## SUBMISSION 2: SUMMARY OF ADDITIONAL CONCERNS IN RELATION TO THE PROPOSED NORTHCONNEX TUNNEL

Application number - SSI 13\_6136

**This is an objection to many aspects of the proposed NorthConnex tunnel.**

MOTORWAY OPERATIONS COMPLEX - SOUTHERN VENTILATION FACILITY - SECTIONS
M1-M2-5000-DR-JD-0525

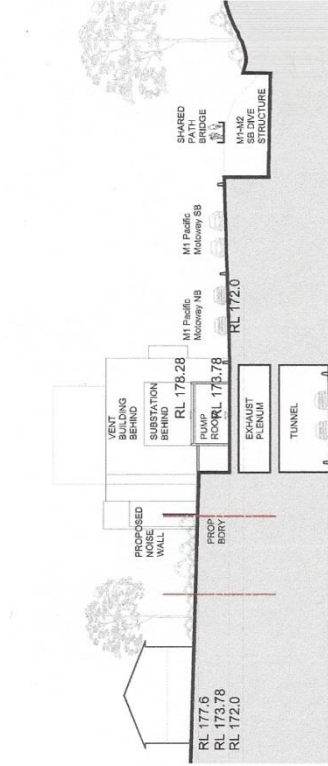
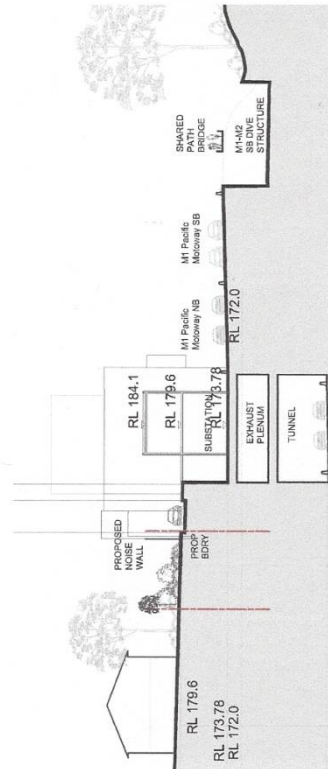
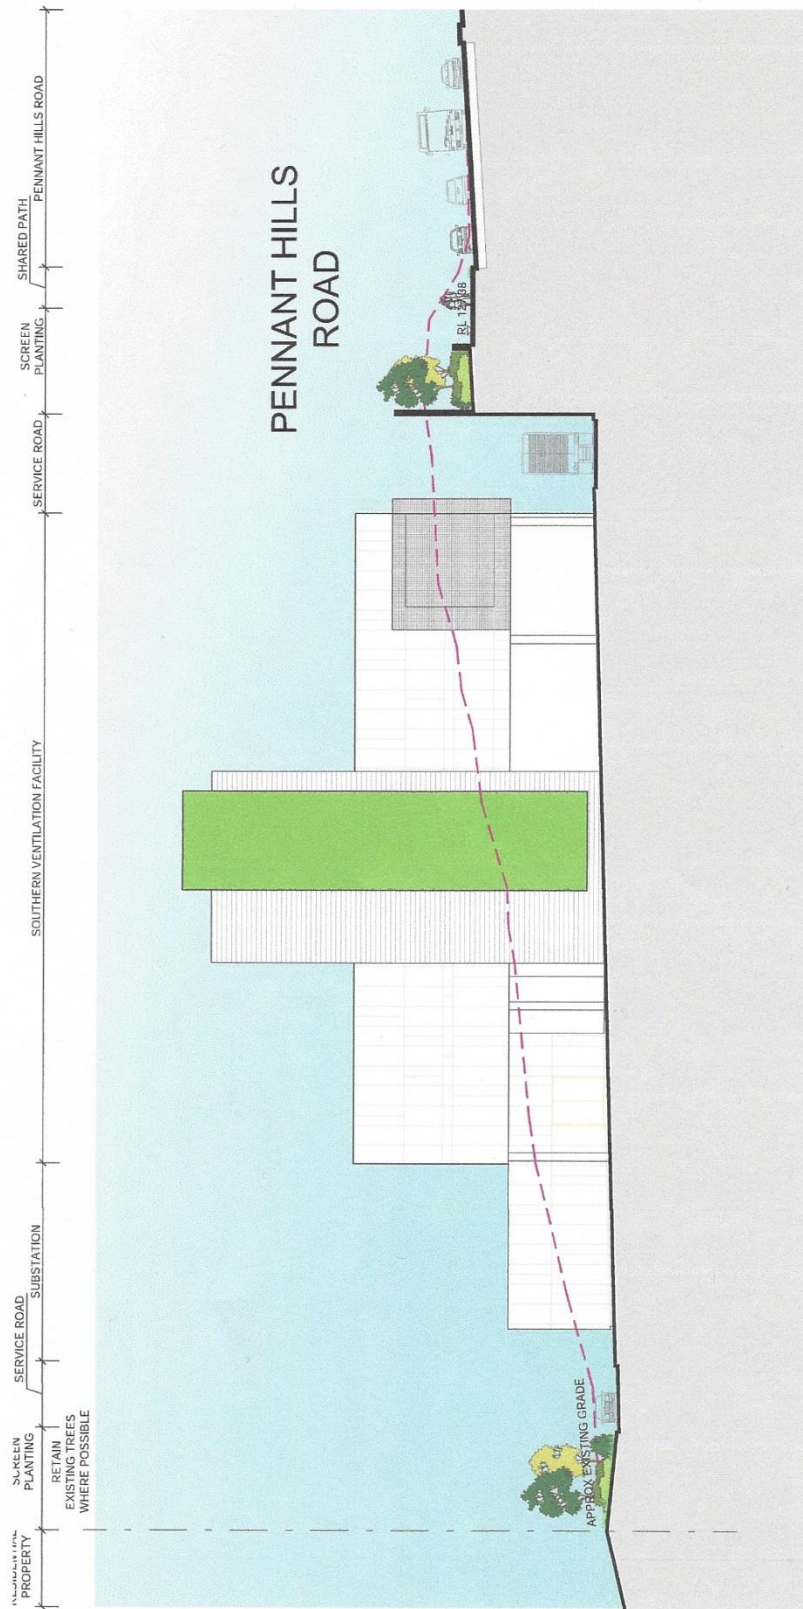
Speakers at the NorthConnex Air Quality Forum spoke of the importance of the topography in the placement of the ventilation facilities. In the NorthConnex proposal the southern ventilation facility is at the lowest point of the M2 intersection where it is surrounded on three sides by hillside cuttings. In this location the “discharge point” will barely be above the adjacent high ground.

Much is made of the intention to discharge the polluted air through the stack at 13 – 19m/s. Given that the stack is only 15m above Pennant Hills Road, a simple calculation indicates that the particles will be ejected to a height of between 23m and 33m above Pennant Hills Road. That will only be sufficient for them to be dispersed by prevailing winds IF there is wind and it is strong enough. For instance, the weather history graph showing the wind speed and direction at West Pennant Hills measured on the 24th August 2014 indicated that there was no wind until 9am and what wind there was, came from the west. Wind speeds of less than 2m/sec (ie about 8km/hour) are not considered sufficient to disperse pollution from the stack. Only a very few gusts on this day were in excess of 8km/hour.

That the Government ensures that the southbound ventilation facility ie the Stack, be located at the south-west corner, on the RMS owned land, at the edge of the Pennant Hills Golf course. In this location, the southbound tunnel can be efficiently, effectively and economically ventilated.

The impact of the stack plumes on the surrounding residential areas must be modelled using its current proposed position and height and also modelled with the stack positioned on the golf course side of Pennant Hills Road, where it is topographically higher. This would allow an objective, impartial, scientifically based assessment to be made of the most effective location for the stack.
